Road Safety Audit Stage 1

Access to Richborough Road, Ash, Sandwich

Client: [DHA Transport](#)

Road Safety Answers reference no: RSA791

### Problems Location Plans

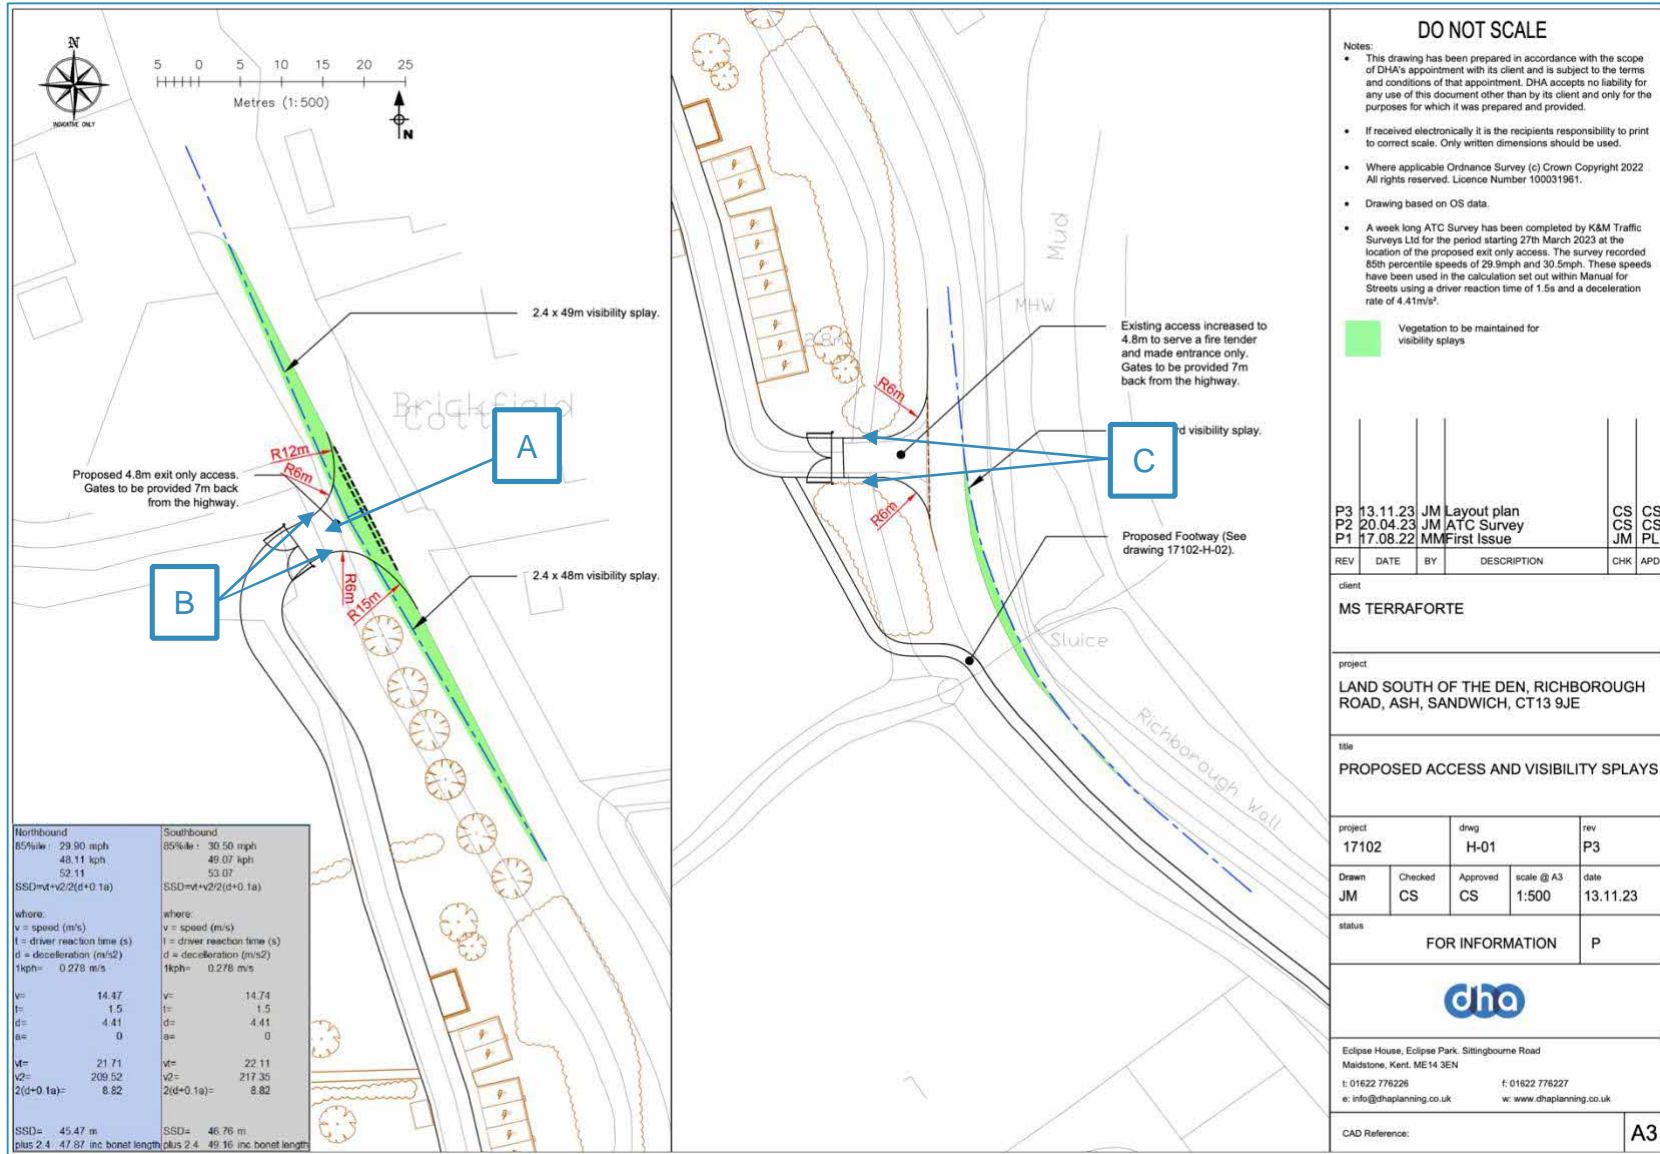
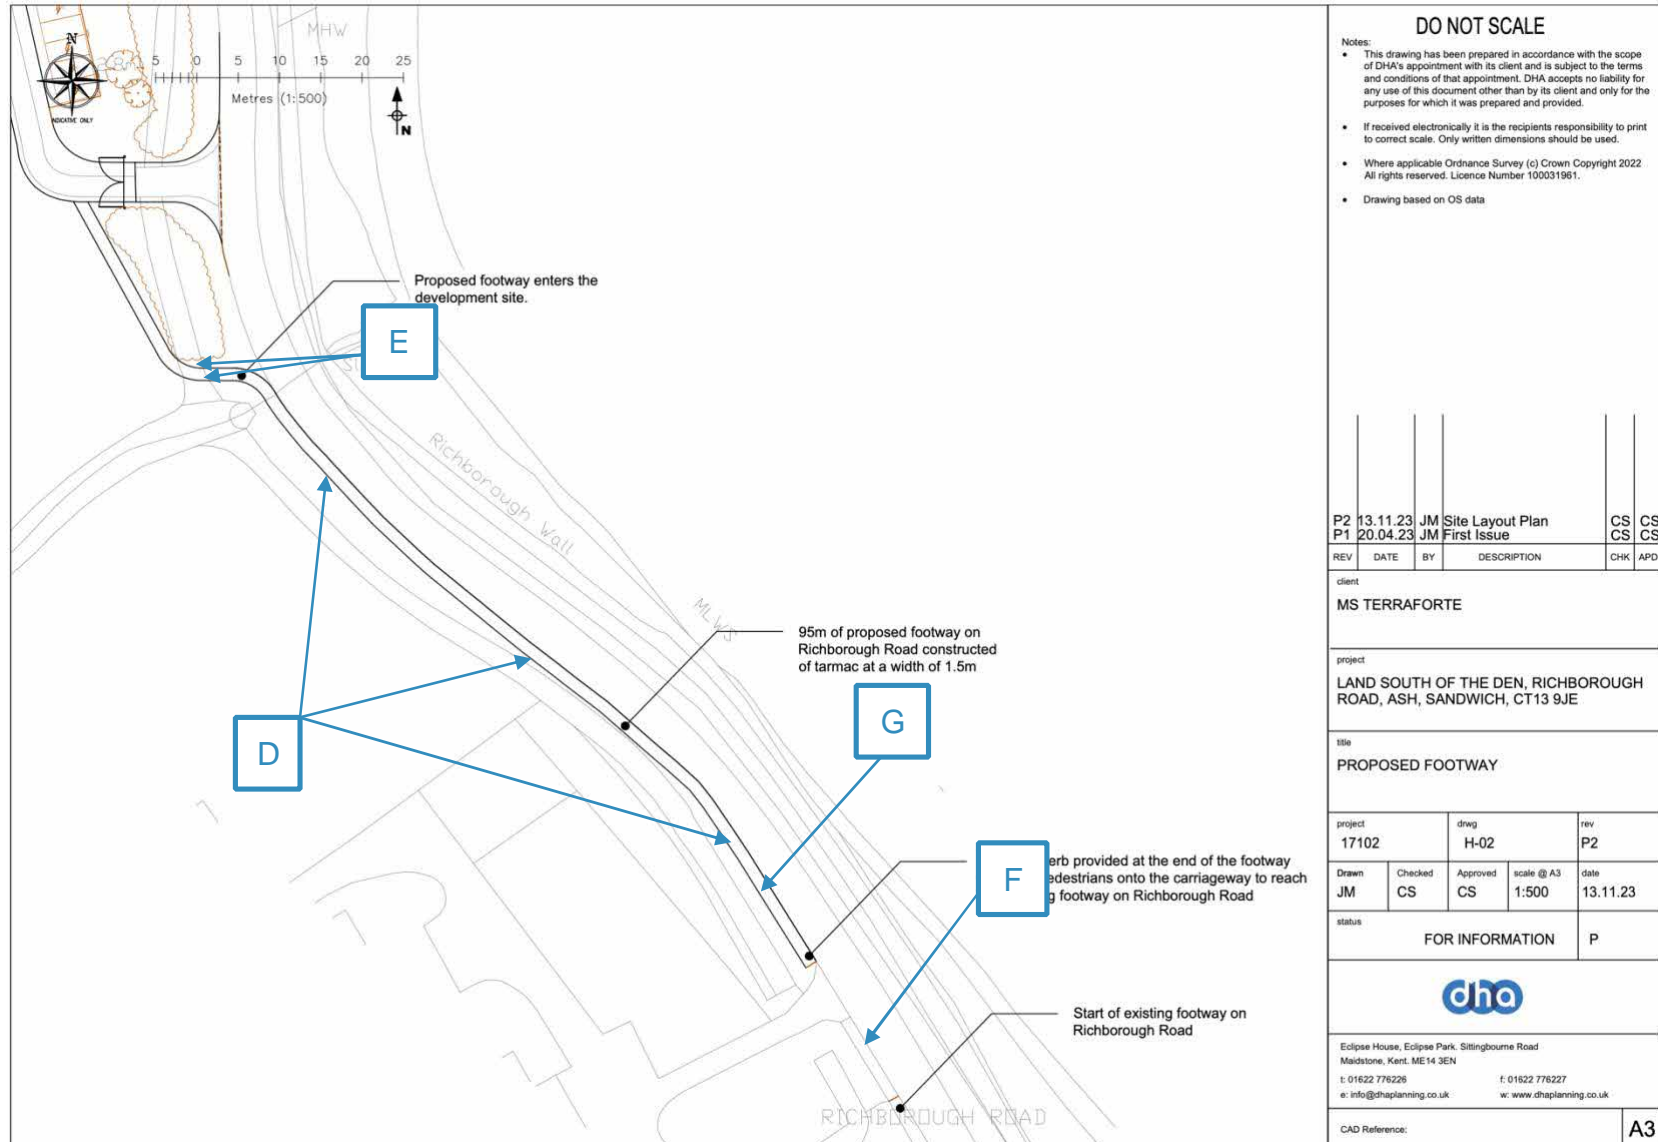
Location: A – The Out-only egress onto Richborough Road (Dwg. 17102/H-01 Rev. P3).

Summary: Risk of an exiting vehicle rolling back onto a following vehicle.

There is currently a gradient up onto Richborough Road of approximately 1 in 8 from the development site. If this is maintained there will be a risk of an exiting vehicle rolling back onto a following vehicle, causing damage.

Location: B – The Out-only egress onto Richborough Road (Dwg. 17102/H-01 Rev. P3).

Summary: Risk of an exiting vehicle falling into the drainage ditch.

A relatively deep drainage ditch runs parallel to Richborough Road along the whole frontage of the site. The drawing implies that the exit road will be kerbed, but does not show any protection to stop an errant vehicle running off the side of the road into the drainage ditch as it turns the right angle to use the exit. The lack of a protective barrier, wall or verge on each side of the exit road, as it crosses the ditch, increases the risk of a vehicle falling into the ditch, with possible injuries to the vehicle occupants.

Locations: C – The In-only access from Richborough Road (Dwg. 17102/H-01 Rev. P3).

Summary: Risk of an entering vehicle falling into the drainage ditch.

The drainage ditch that runs parallel to Richborough Road along the whole frontage of the site is particularly deep at the proposed access to the site. The drawing implies that the entry road will be kerbed, but does not show any protection to stop an errant vehicle running off the side of the road into the drainage ditch as it turns into the access. The lack of a protective barrier, wall or verge on each side of the exit road, as it crosses the ditch, increases the risk a vehicle falling into the ditch, with possible injuries to the vehicle occupants.

The egress should have a relatively level dwell area approaching Richborough Road.

The exit road should have protection on each side as it crosses the drainage ditch on the approach to Richborough Road.

The access road should have protection on each side as it crosses the drainage ditch next to Richborough Road.

Location: D – The 95m of footway along the verge of Richborough Road (Dwg. 17102/H-02 Rev. P2).

Summary: Risk of pedestrians falling into the deep ditch.

The verge on the west side of Richborough Road falls from what will be the back edge of the proposed 1.5m footway into the deep ditch that runs along this whole stretch of road (photo 1). Without a flat margin behind the footway onto which an errant pedestrian can step, the risk of the pedestrian losing their balance on the slope and falling into the ditch will be unnecessarily high.

Location: E – Northern end of the footway where it enters the development site (Dwg. 17102/H-02 Rev. P2).

Summary: Risk of pedestrians falling into the deep ditch.

As the footway leaves the edge of the carriageway of Richborough Road it will have to bridge across the deep ditch. Without any protection on each side the risk of errant pedestrians falling into the ditch will be unnecessarily high.

Location: F – Southern end of the proposed footway (Dwg. 17102/H-02 Rev. P2).

Summary: Risk of pedestrian/vehicle collisions on the carriageway.

Pedestrians will have to walk on the carriageway as the proposed footway will stop 19m short of the existing footway (photo 2), increasing their risk of collisions with passing vehicles.

Location: G – Towards the southern end of the proposed footway (Dwg. 17102/H-02 Rev. P2).

Summary: Risk of pedestrian/vehicle collisions.

The existing pole with the national speed limit/30mph signs is located in what will be the centre of the proposed footway. If left in situ, mobility impaired pedestrians using a mobility scooter will be unable to pass it on the footway and will have to travel on the carriageway for 120m to use the vehicle entrance to the development site, increasing their risk of being struck by a passing vehicle.

Measures should be installed to ensure that pedestrians do not fall into the ditch.

Measures should be installed to stop pedestrian falling into the ditch as they cross it on the bridge.

The proposed footway should continue southwards to join the existing footway.

The speed limit pole and signs should be relocated to the verge behind the proposed footway.
